**KIRKLEES METROPOLITAN COUNCIL  
INVESTMENT & REGENERATION SERVICE**

**DELEGATED DECISION FOR APPLICATION FOR CERTIFICATE OF  
LAWFUL DEVELOPMENT**

Reference no.: 2025/CL/90942/W

Site: Moss Edge Farm, Moss Edge Road, Holmbridge,  
Holmfirth, HD9 2SD

Client:		ANTHONY DEARNLEY HOMES.	
Project:		MOSS EDGE FARM, MOSS EDGE ROAD, HOLMBRIDGE, HD9 2SD	
Drawing:		PROPOSED ELEVATIONS 1.	
Project No:	1835	Drawing No:	03_01
Scale:	1:50	Date:	MAR '25
Drawn by:	DW	Checked by:

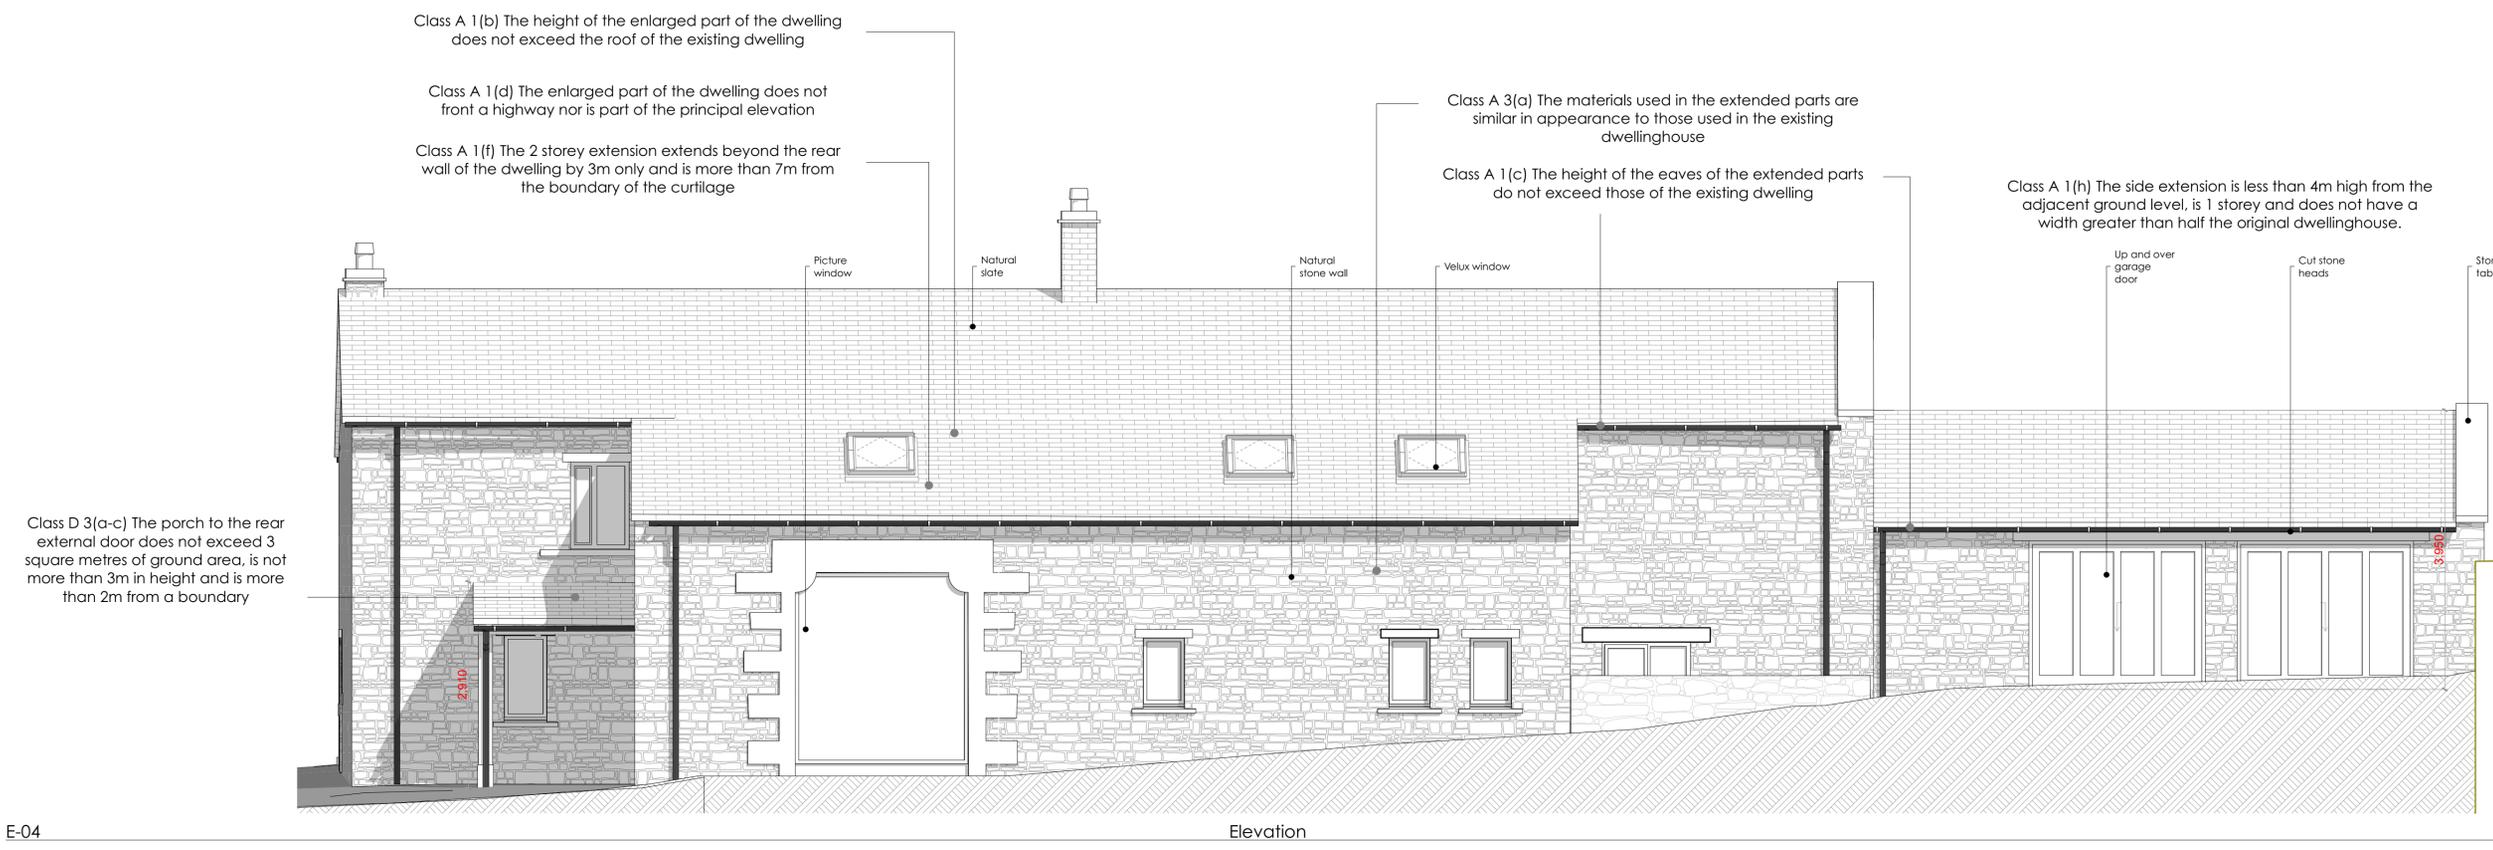
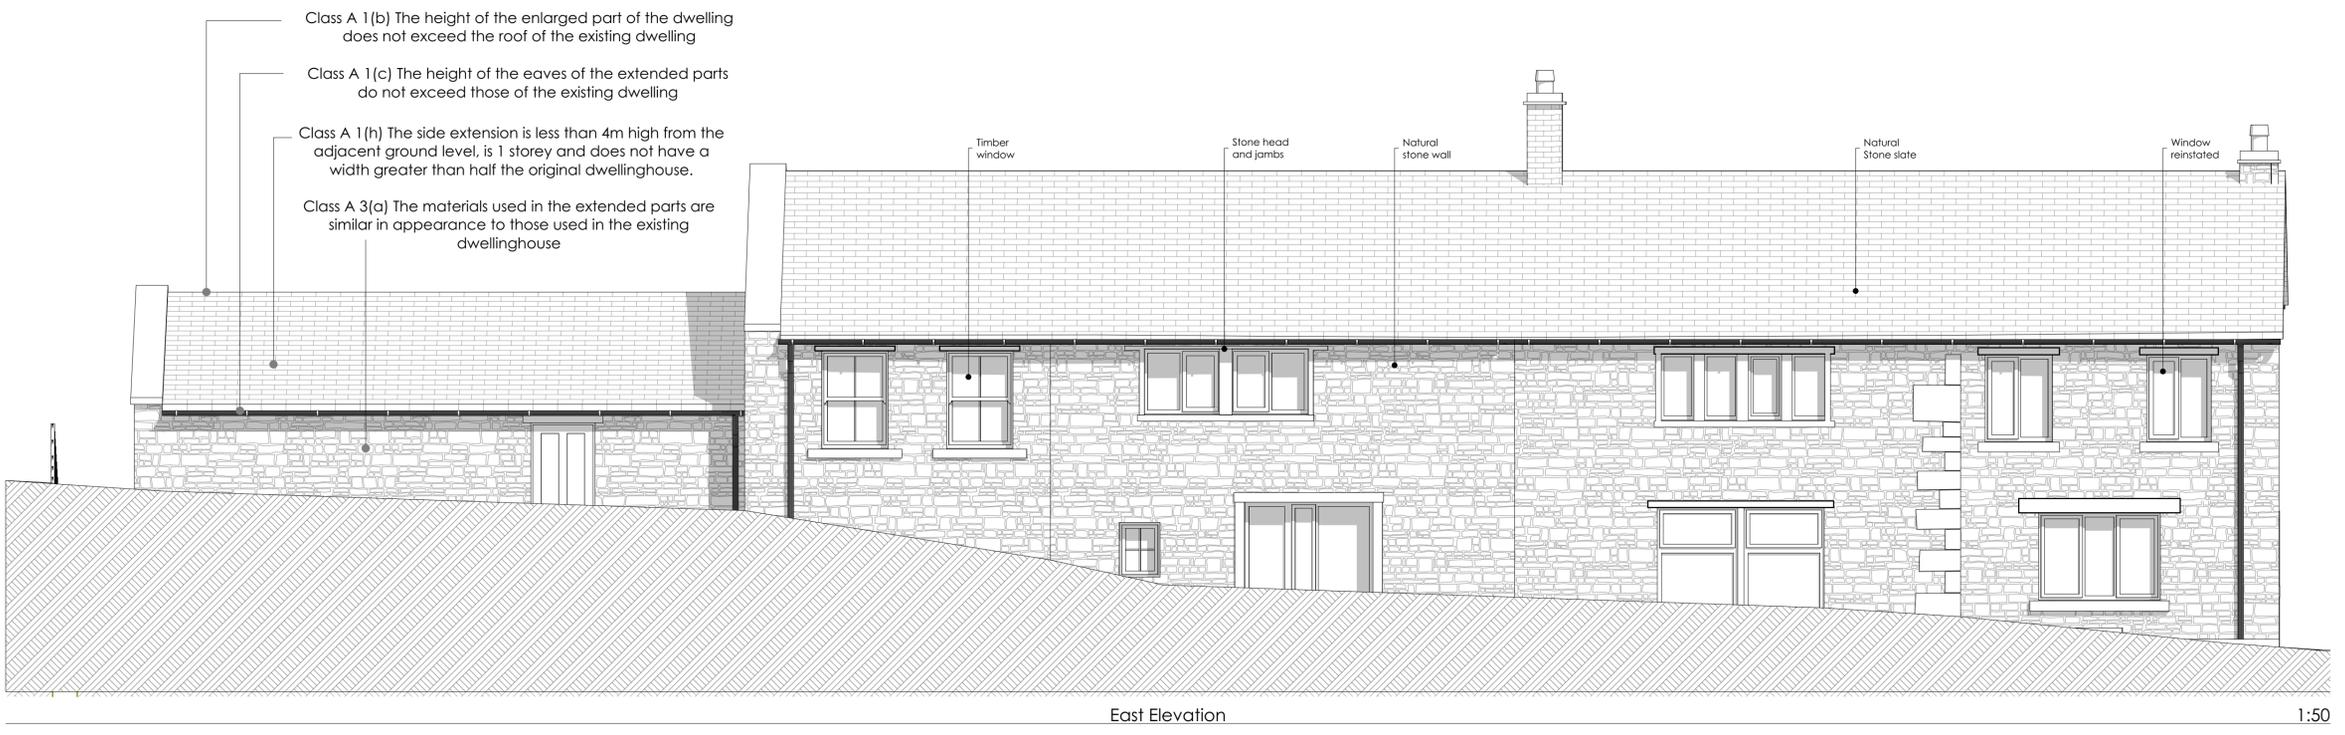
**Comment:** *The extension would have more than a single storey however is proposed to project less than 3 metres beyond the rear wall of the dwellinghouse. However, as the existing west elevation is considered to be the extent of curtilage, the proposed extension would be within 7 metres of the boundary of the curtilage of the dwellinghouse.*

**Comment:** *The eaves height of the extension is 2.9 metres.*

Drawing: PROPOSED PLANS

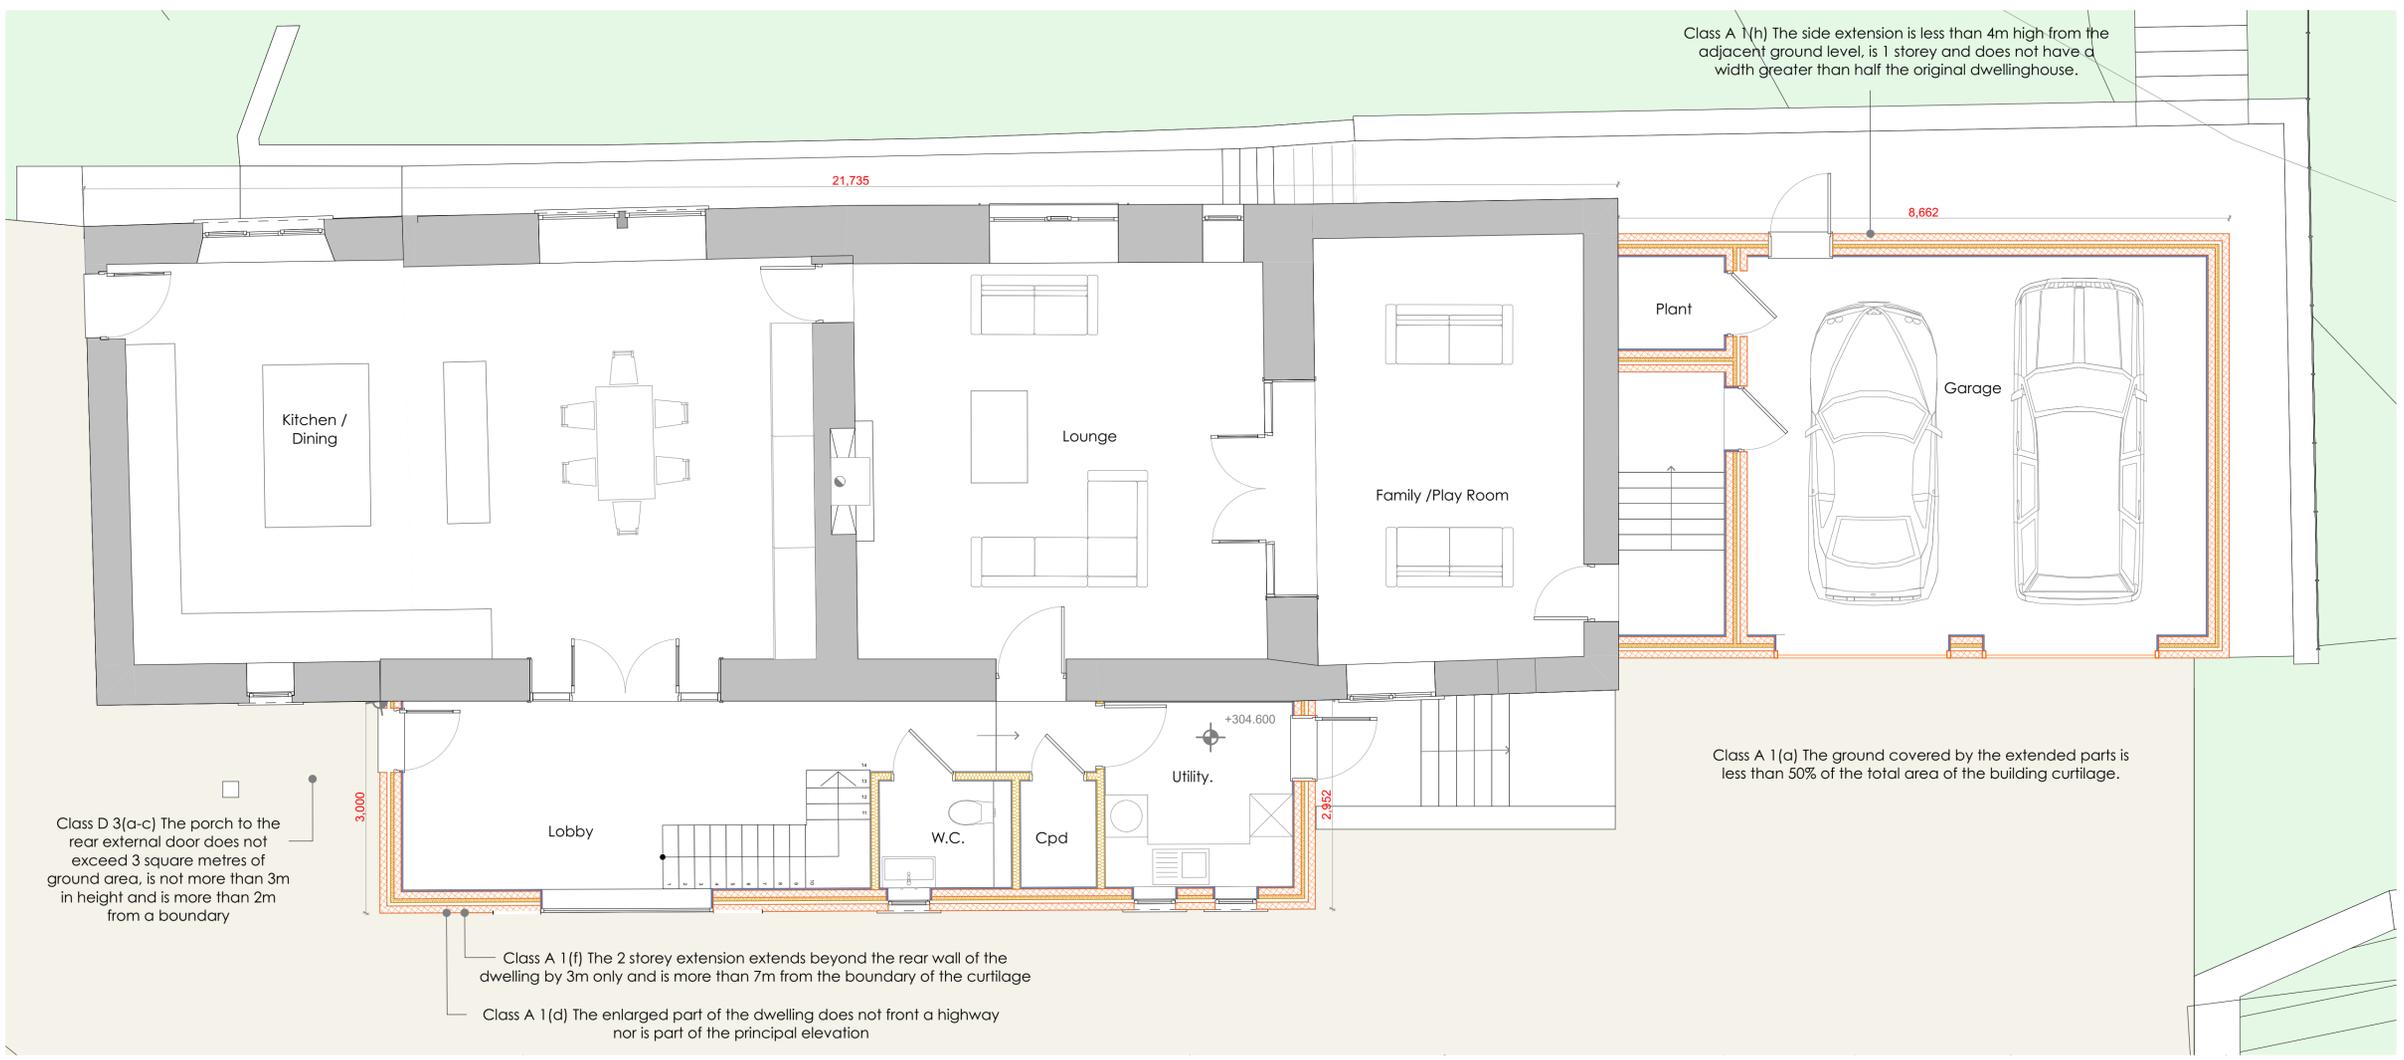
The garage side extension is proposed to the southern elevation of the dwelling and is proposed to have a height of 3.9 metres and a width of 8.6 metres. Due to the proposed location of the garage, it raised the question of the extent of residential curtilage in this instance. Aerial imagery from 2000 appears to clearly demonstrate that the land immediately surrounding the dwellinghouse has been used in connection with the agricultural use of the attached field as opposed to be garden, parking or other uses that could be considered associated with the farmhouse. There had been no defined curtilage in connection with the property until recent years where an area to the west of the property has been sectioned from the adjacent field.

The area where the garage is proposed has not been defined or used in connection with the residential use of the dwelling. When considering established Court judgements, any curtilage land must have the qualities of land that is intimately associated with the dwellinghouse both past and present and be undoubtably regarded as one enclosure with the dwellinghouse<sup>1</sup>. In this instance there is no evidence to show the land to the south is intimately associated with the dwellinghouse despite being in the same ownership and there are no physical or functional boundaries to show the land was not part of the wider farmed field. It is noted that historical maps do show some feature, whether land or building which has historically been removed. This is not considered sufficient to demonstrate the land continued to be part of any curtilage notwithstanding any original use and the land south of the building has clearly been used for agricultural purposes for at least the previous 25 years.

Consequently, it cannot be concluded that the land where the proposed garage is located has clear functional links to the dwelling and therefore cannot be considered as being curtilage to Moss Edge Farm.

Equally, the land to west beyond where the proposed two storey enlargement is proposed appears to historically be part of the farm yard and has not been used for any domestic purpose associated with the farmhouse and therefore the curtilage boundary on the west elevation is considered to be the west side of the existing building.

**Comment:** *The garage extension would project beyond a wall forming a side elevation of the original dwellinghouse but is not more than half the width of the original dwellinghouse. The two storey enlargement also projects beyond an original side elevation and has more than a single storey although this part is considered to extend beyond residential curtilage.*

Site Plan Proposed

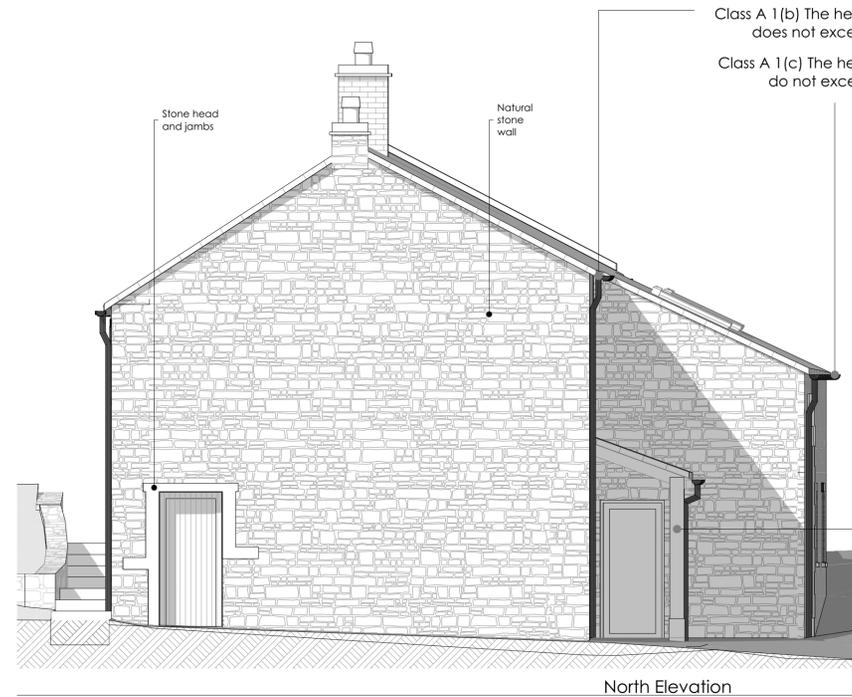
An area of land projecting approximately 4 metres to the east of the existing farmhouse along the entire length of this elevation appears to have been annexed from the wider field with some degree of physical feature. It is not sufficiently clear from aerial imagery to established whether this is used for purposes associated with the dwellinghouse. However there is no evidence to demonstrate the land was part of the wider field prior to 2021 and no residential use or curtilage appears to have been established on the east elevation.
